TII ref. TII24-126615

Re: Strategic Infrastructure Development – Further Information Submitted in relation to Proposed no. 8 wind turbines and associated works at Laurclavagh and adjacent townlands, Co. Galway

ACP Case ref. PA07.319307

The Authority acknowledges receipt of referral of Further Information in relation to the above Strategic Infrastructure Development application on behalf of Laurclavagh Limited and provides the following observations for the Commissions consideration;

PROJECT TITLE:			
Laurclavagh Renewable Energy Development, Co. Galway			
DRAWING TITLE:			
Proposed access junction off the L-61461			
PROJECT No.:	DRAWING No.:	SCALE:	
210627	210626 - 39	1:1,000 @ A3	
DRAWN BY:	CHECKED BY:	DATE:	REVISION.:
JOB	TH	13.03.2024	P01

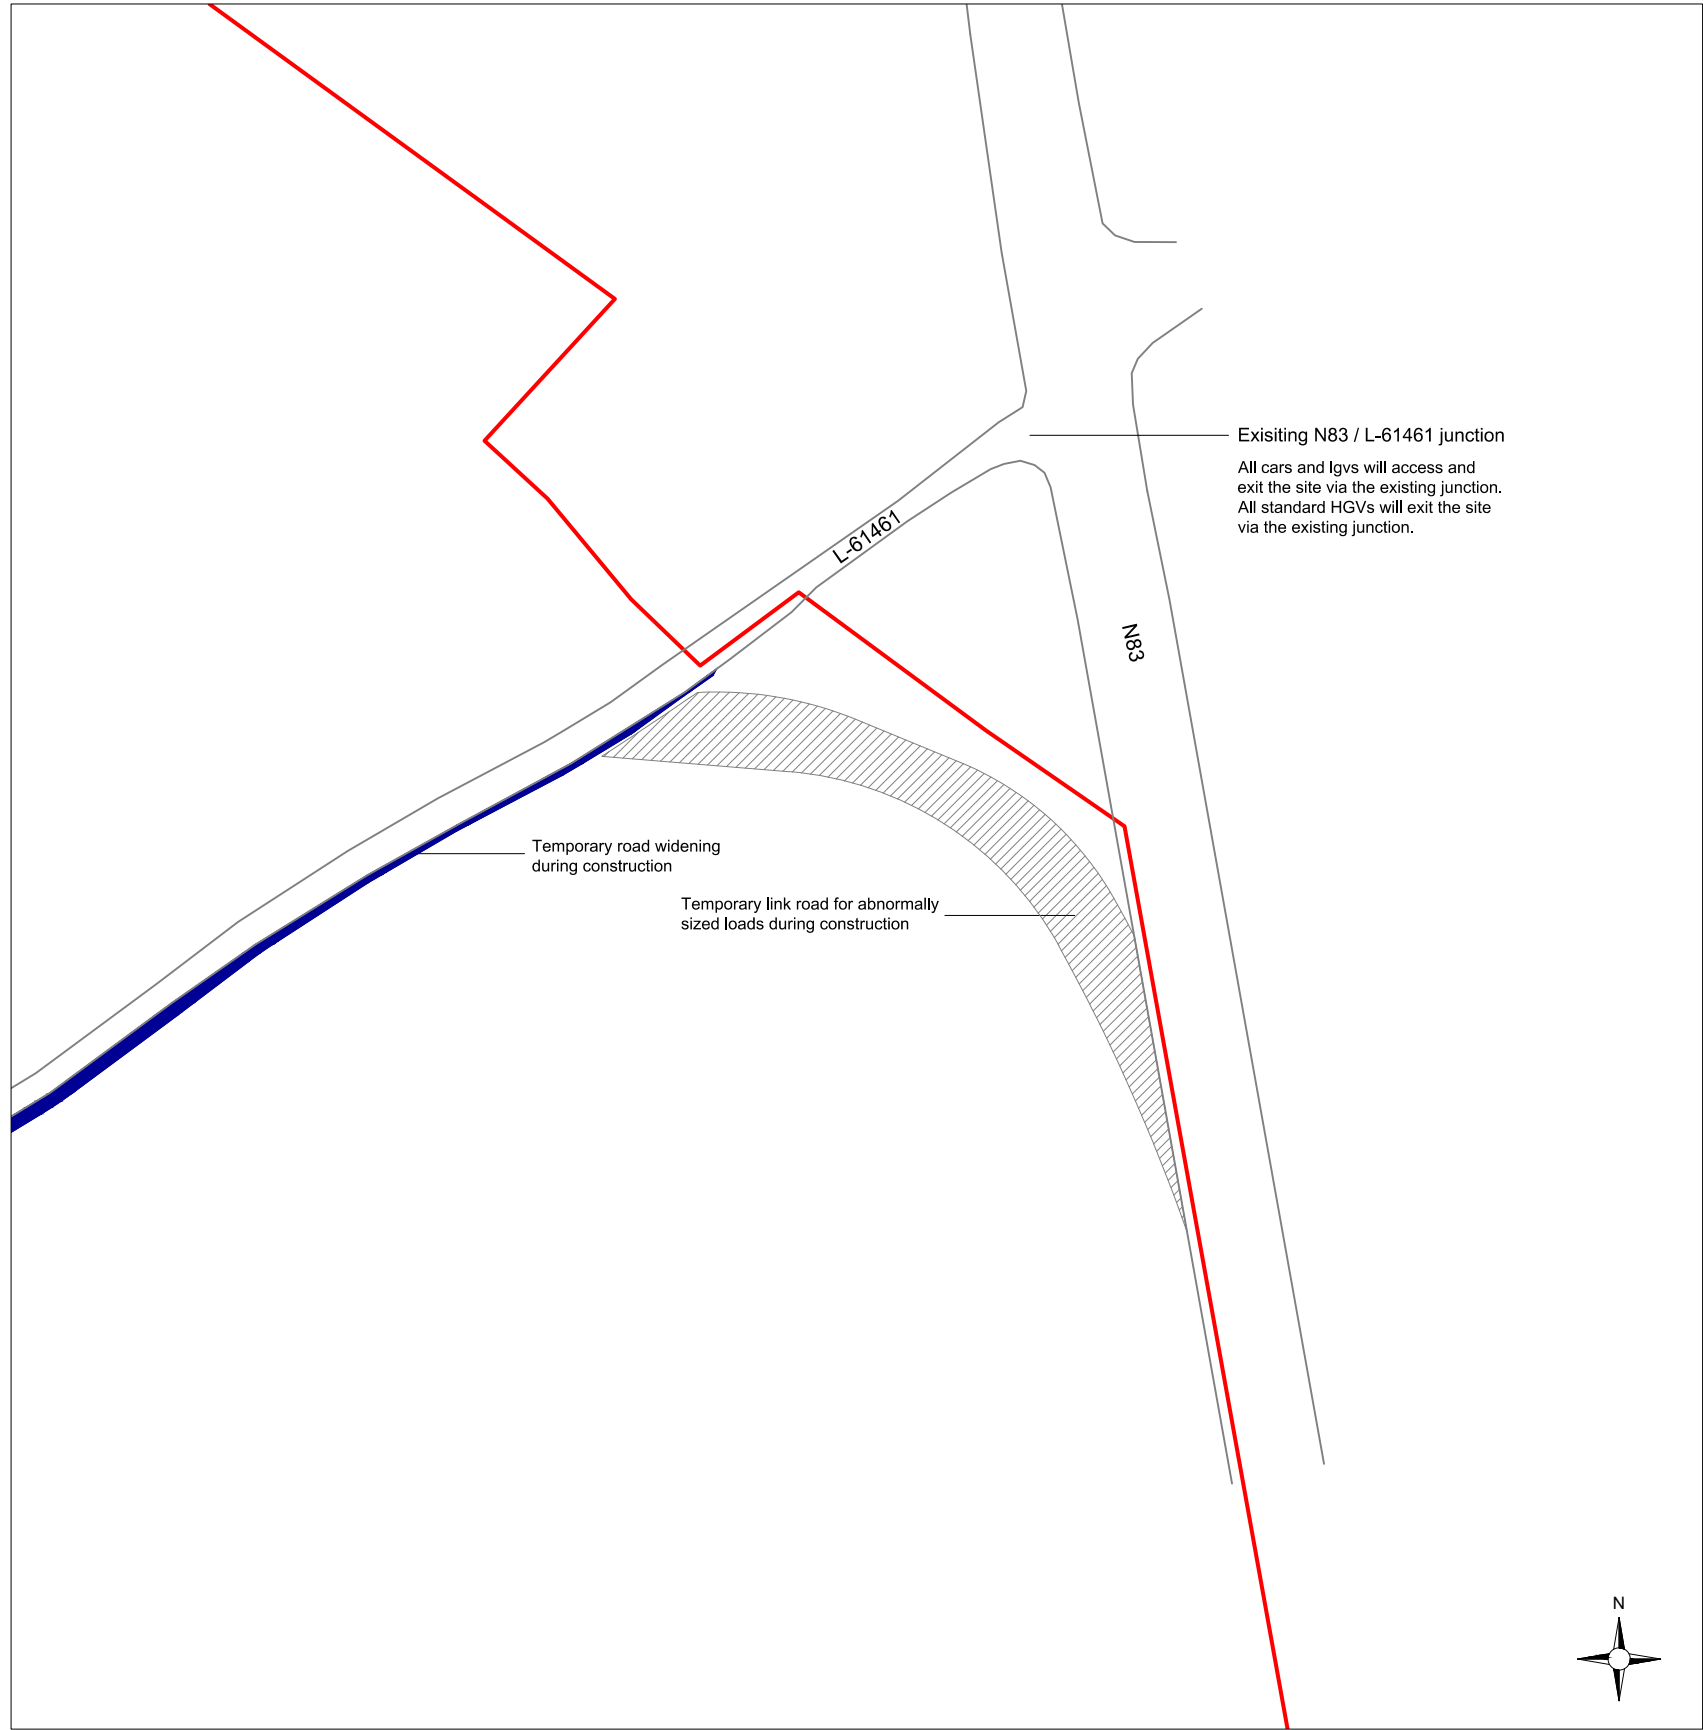
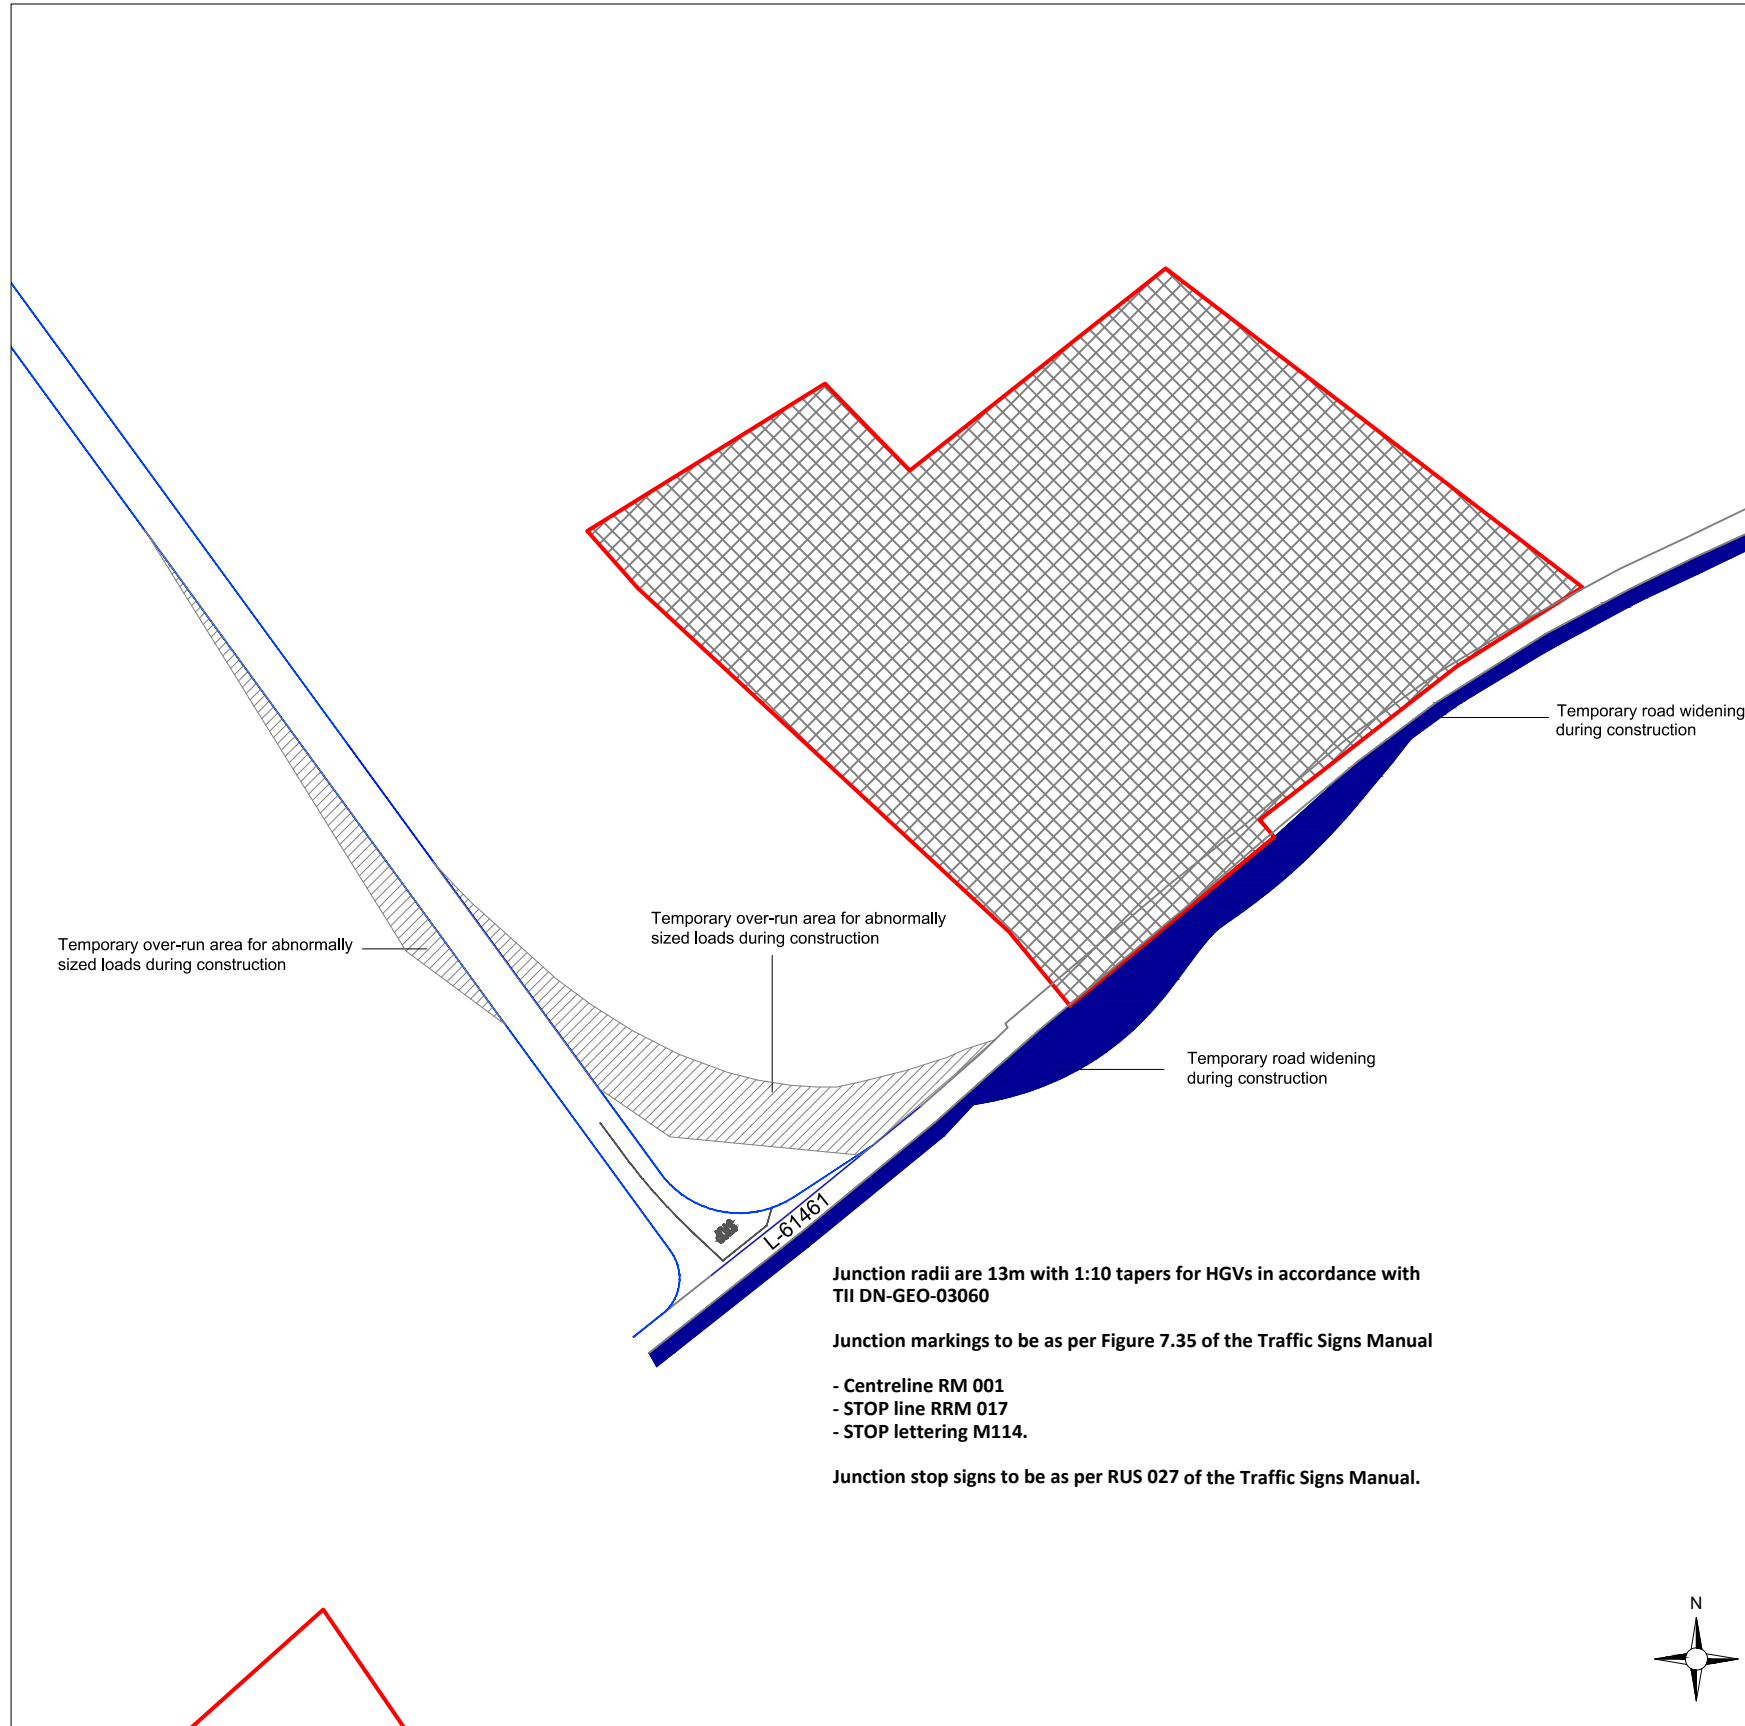
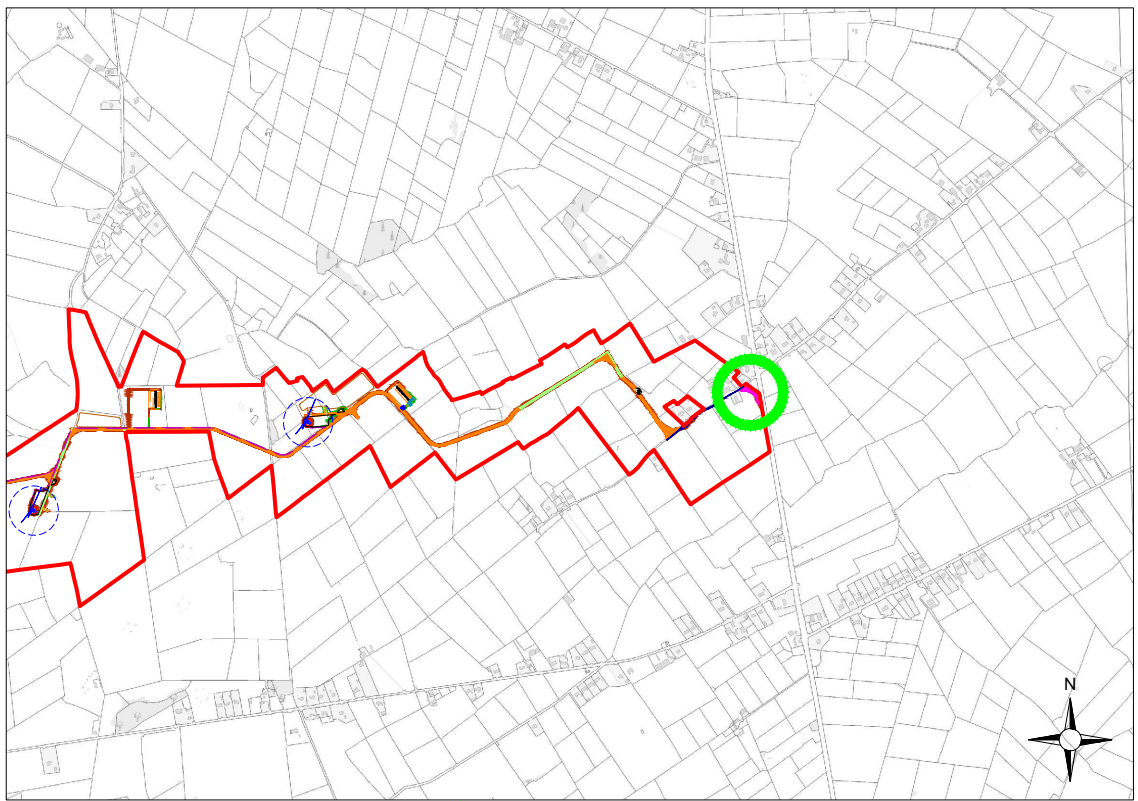
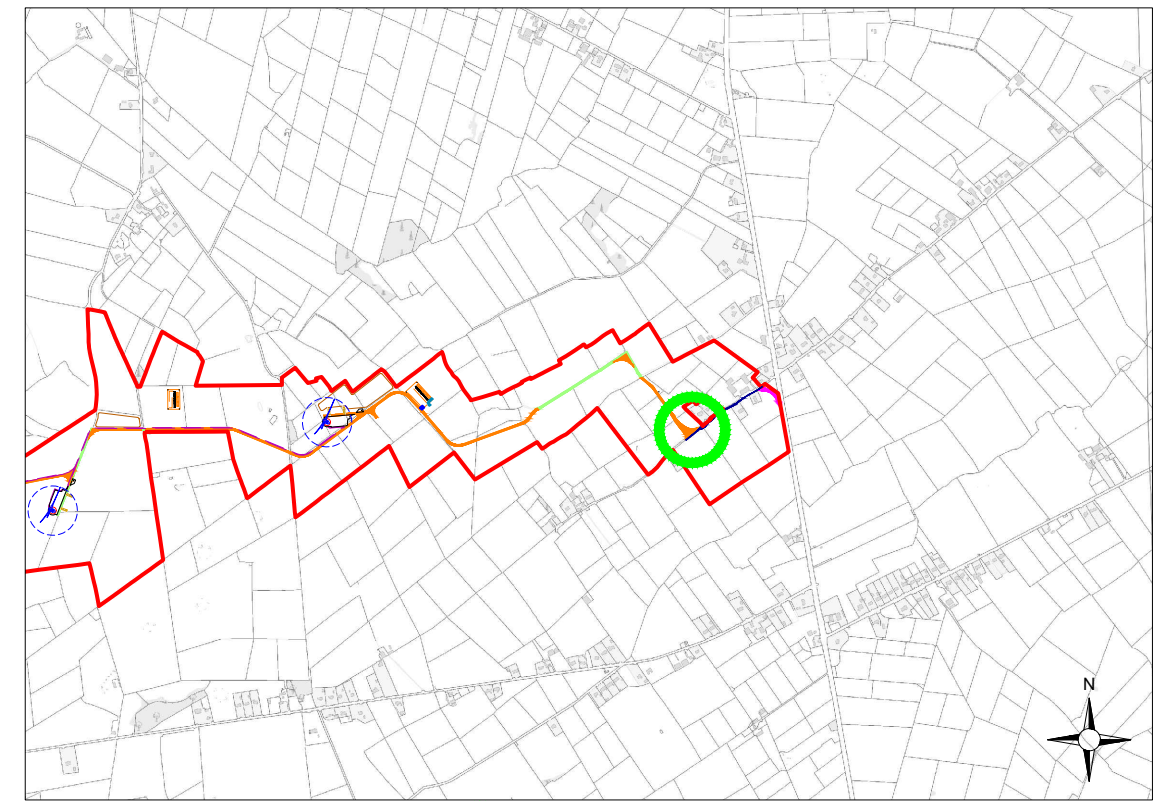
In relation to the subject application, it is noted that access is generally provided to the N83, national road, via the L61461 local road, however, access requirements include proposals to construct a temporary access track at the N83, national road, to L61461, local road, to be used for the delivery of oversize turbine components to site. TII's records indicate that a 100kph speed limit applies to the section of N83, national road, concerned.

The documentation submitted in support of the proposed development (drawing no. 210627 - 34) outlines that the access track and temporary roadside fencing will be removed following the commissioning of the wind farm and lands and roadside boundaries will be reinstated.

- The proposed temporary access is for a temporary period only to facilitate turbine component delivery and the temporary access to the N83 shall thereafter be closed and lands reinstated. TII considers that this access arrangement should be closed following completion of the construction phase of development in the interests of road safety and adherence to the provisions of official policy.

- The temporary access to the N83, national road, should be closed off with a temporary safety barrier when not in use for turbine component delivery, as it could be misinterpreted by drivers as part of the roadway. Pending completion of construction, the temporary access shall thereafter be permanently closed and the lands and roadside boundaries reinstated.

- Any damage caused to the pavement on the existing national road at the temporary access from the N83, national road, due to the turning movement of abnormal loads (eg. tearing of the surface course) shall be rectified in accordance with TII Pavement Standards and details in this regard shall be agreed with the Road Authority prior to the commencement of any development on site.

110kV JOINT BAY DETAIL
SCALE 1:25

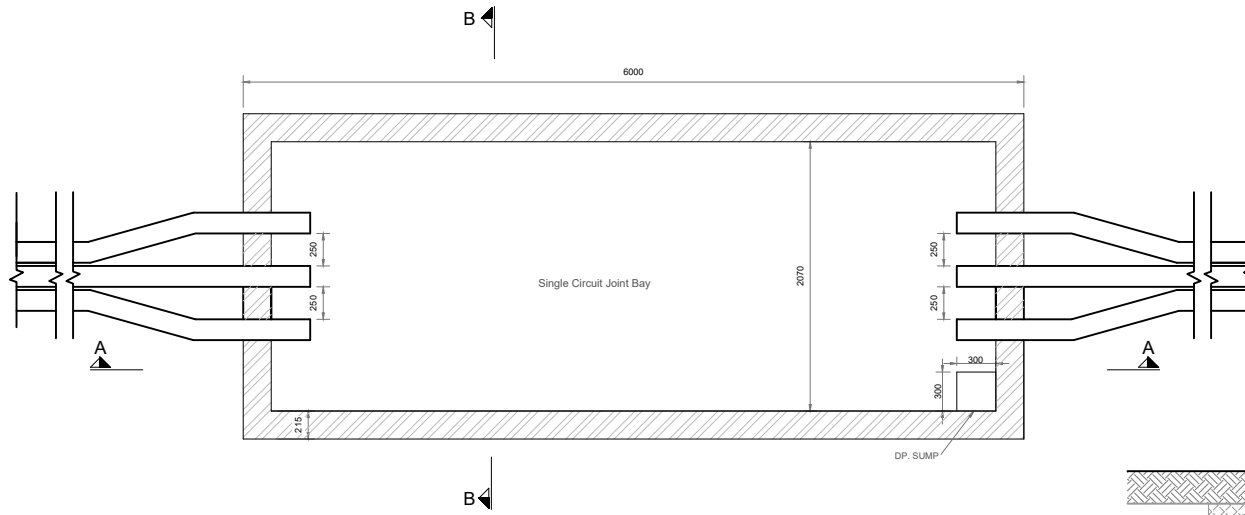
EIAR Appendix 4-8 'Grid Connection Infrastructure' details that 11 no. joint bays are proposed in the N83, national road, and one HDD Crossing of the M18 is proposed.

Section 4.7.2.8 of the EIAR states that the precise siting of all Joint Bays, Earth Sheath Link Chambers and Communication Chambers within the planning corridor assessed is subject to approval by ESNB and Eirgrid. However, the drawing notes included on the standard detail drawings, for example Fig. 4-14 and Fig. 4-18, advise that the exact location of cable/joint bay in the road curtilage will be subject to ESB/EirGrid specifications and agreement with Galway County Council.

TII considers that the agreement with the relevant road authority is a necessary requirement having regard to the potential significant negative impact on the strategic national road network arising from the installation of joint bays, the extent of cabling proposed and the limited level of detail in relation to joint bay location included in the subject application.
